SUBJECT: Engineering Review Comment  
Mountain View Electric Association Inc. (MVEA)

**Project Name: Winsome Filing 3 – Final Plat**

**Project Number: SF229**

**Description:** Proposed development of 38 residential lots and 5 tracts on approximately 350 acres located NW of the intersection of Hodgen Rd. and Meridian Rd. in Township 11S, Range 65W, Sections 13 and 24.

**WINSOME FILING NO. 3  
FINAL PLAT**

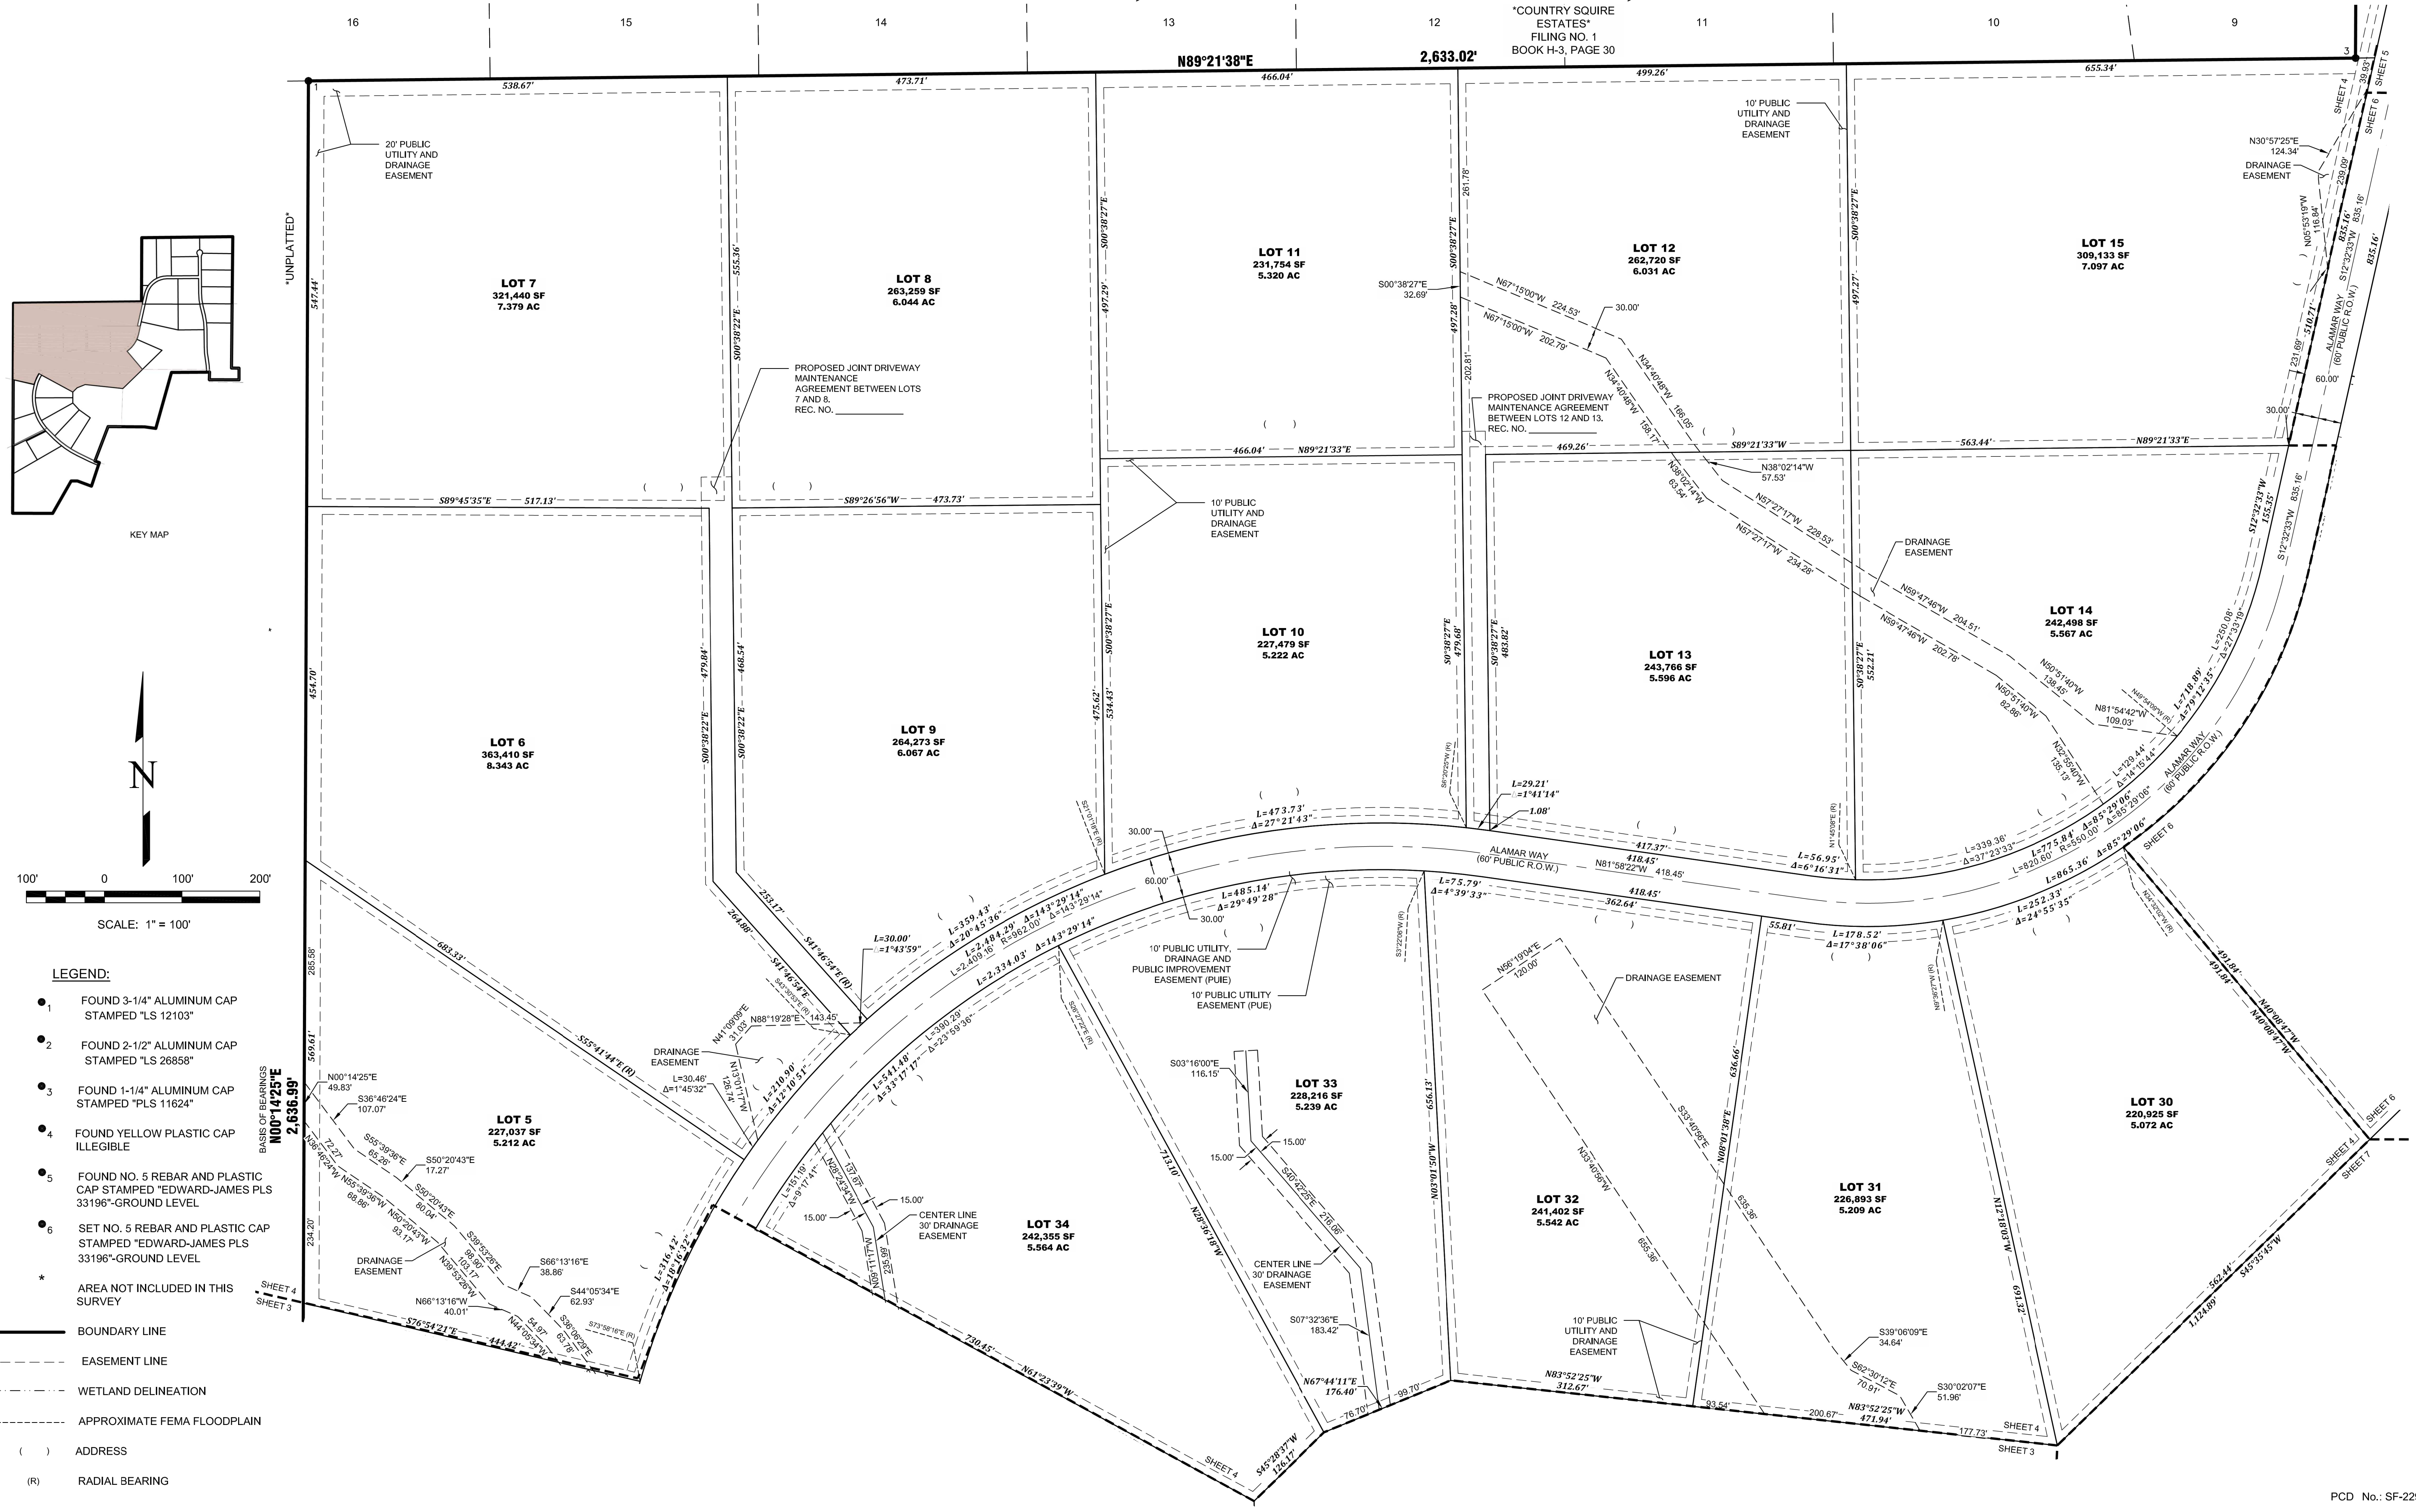
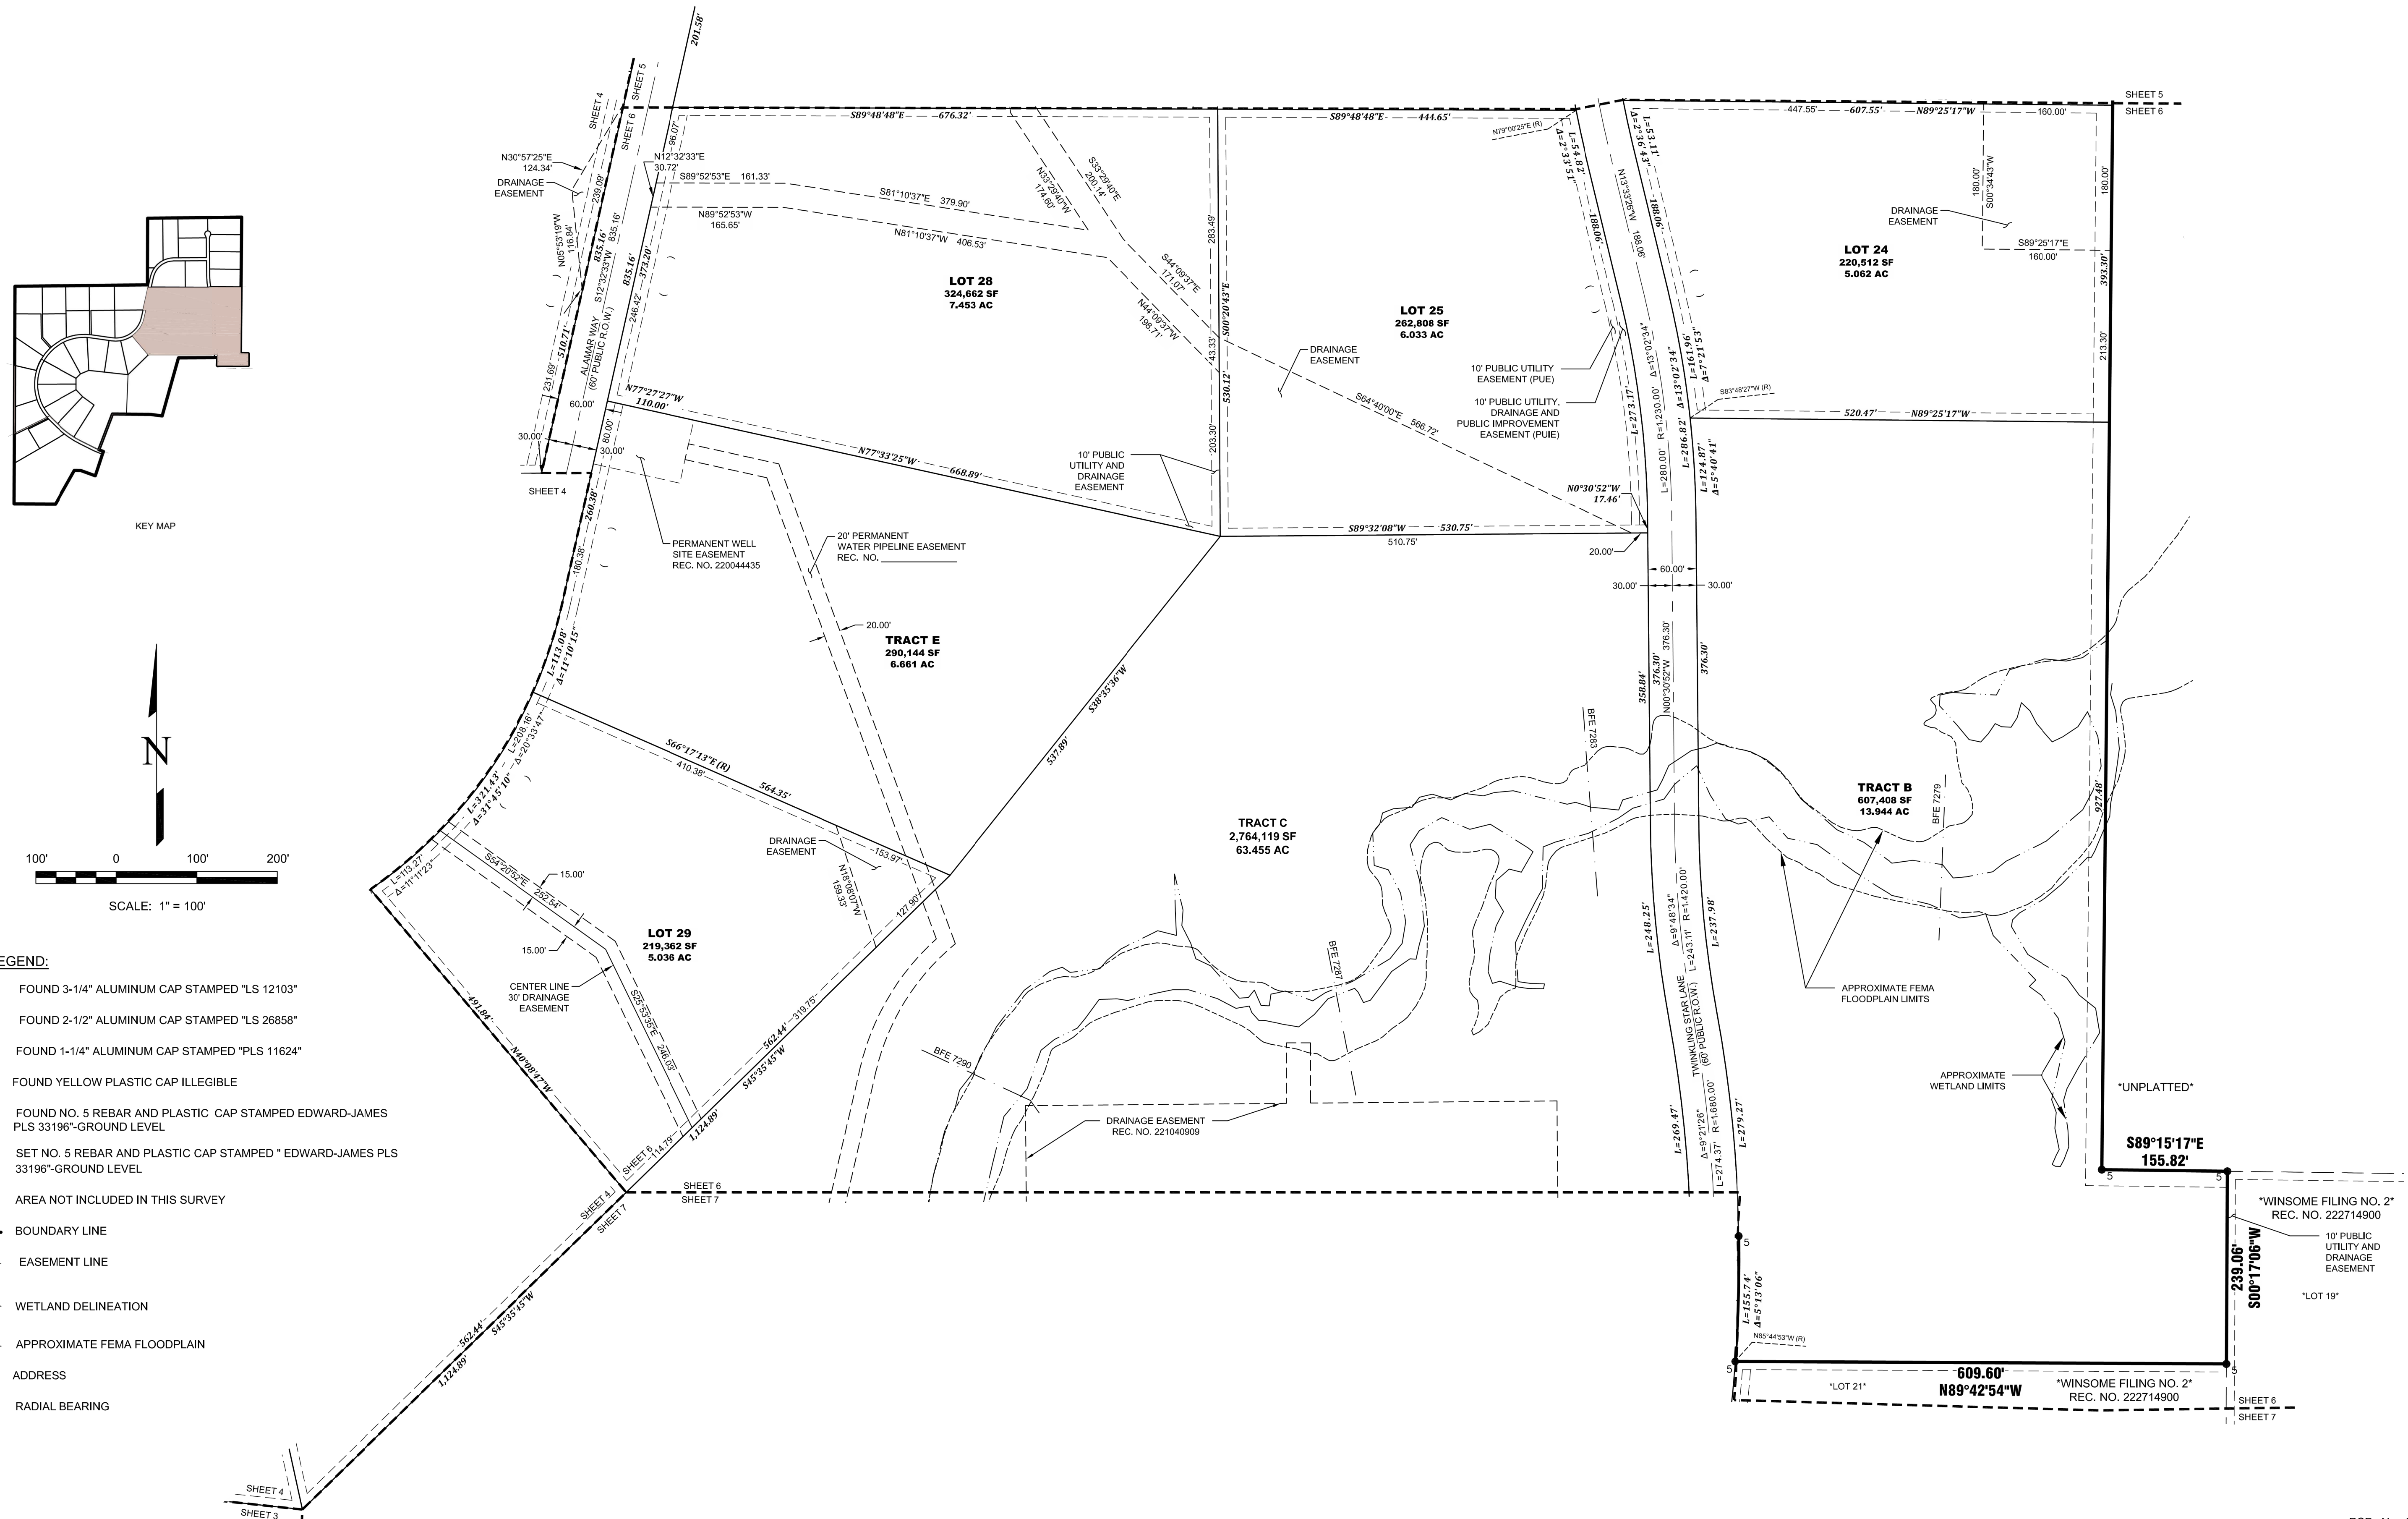
MVEA requests a ten (10) foot utility easement adjacent to the R.O.W. preservation easement and include Tract A/all tracts as public utility. MVEA also requests the platting of MVEA's existing facilities with easements on the plat.
